**VINE COTTAGE
HIGH STREET
ANGMERING
WEST SUSSEX
BN16 4AE**

10/5/2014

re: Planning Application A/46/14/HH
on 2 Woodford Villas High Street Angmering

Retention of infill Brickwork to front boundary wall adjacent to the highway must be refused.

DRAWING TITLE
NEW FRONT BOUNDARY WALL
ELEVATIONS, PLAN AND SECTION

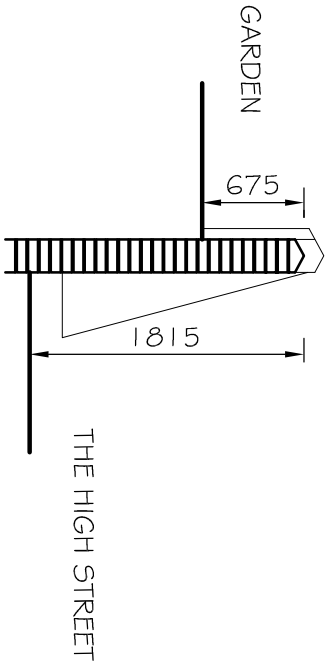
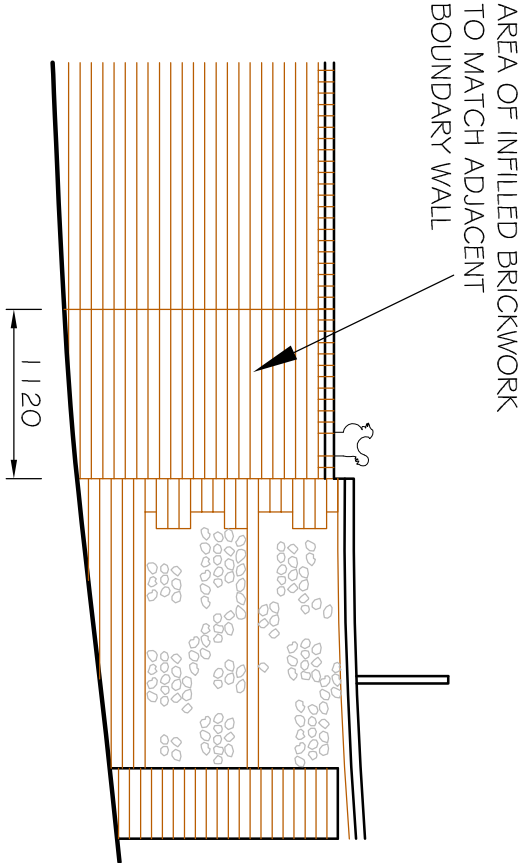
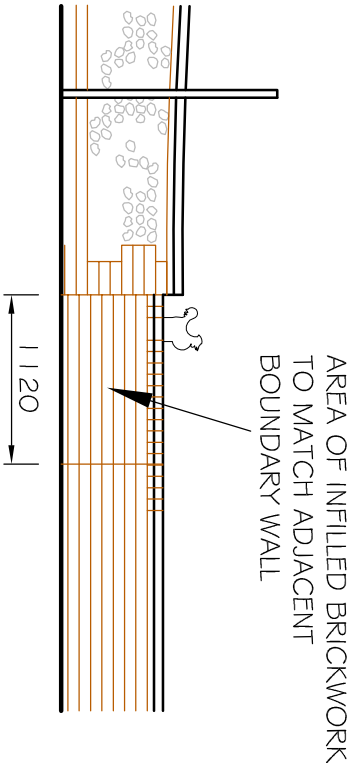
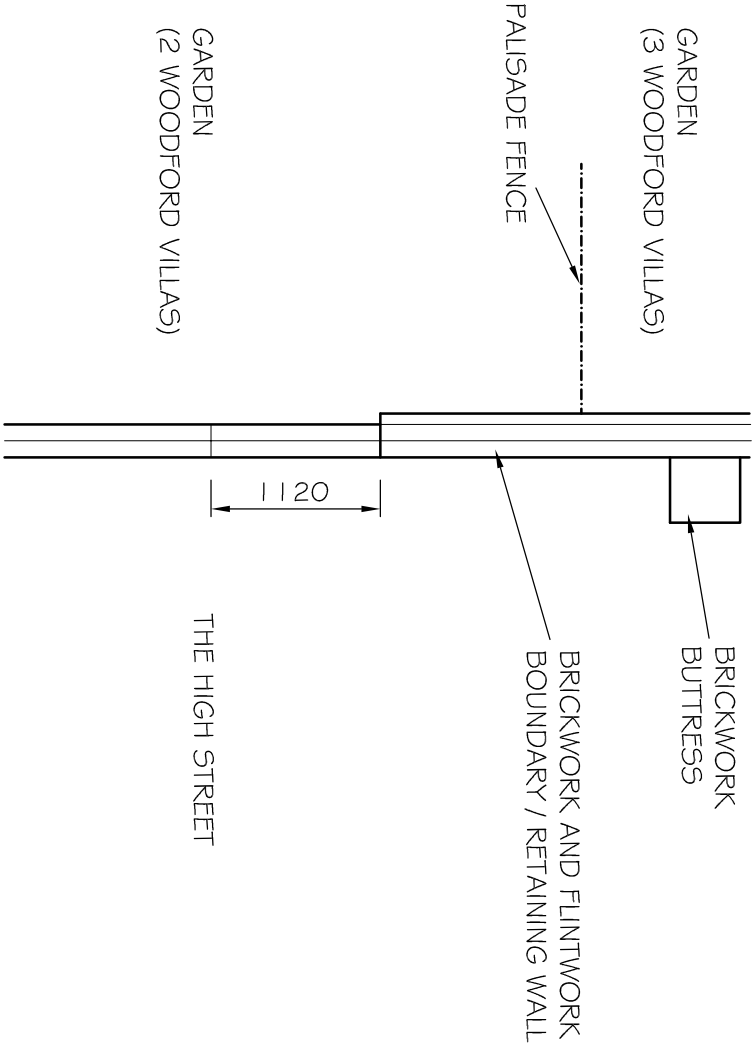
I consider therefore that the stepped path in front
of 2 Woodford Villas having been completely filled in and

obliterated, and the erecting of brick wall as viewed from the highway is blatantly unlawful, and remains so. No order was advertised for the public to see - so no one could object in the formal way, before it happened.

The steps previously outside 2 Woodford Villas matched the steps opposite, leading from the public footpath to the highway - the two openings formed part of the character of this immediate area, opposite to each other.

The bricks in front of 2 Woodford Villas do not continue the style of flint walling - and bricks are of a new look rather than aged. The inappropriate chicken ornament is completely unsuitable to the feel of the surrounding Conservation Area and should be removed.

infill should be taken away, and the stepped footpath should be reinstated. As it is, the illegal full height wall looks incongruous, and there is no way a legal wall of 1 metre height would look correct - so total reinstatement of the original must be enforced.
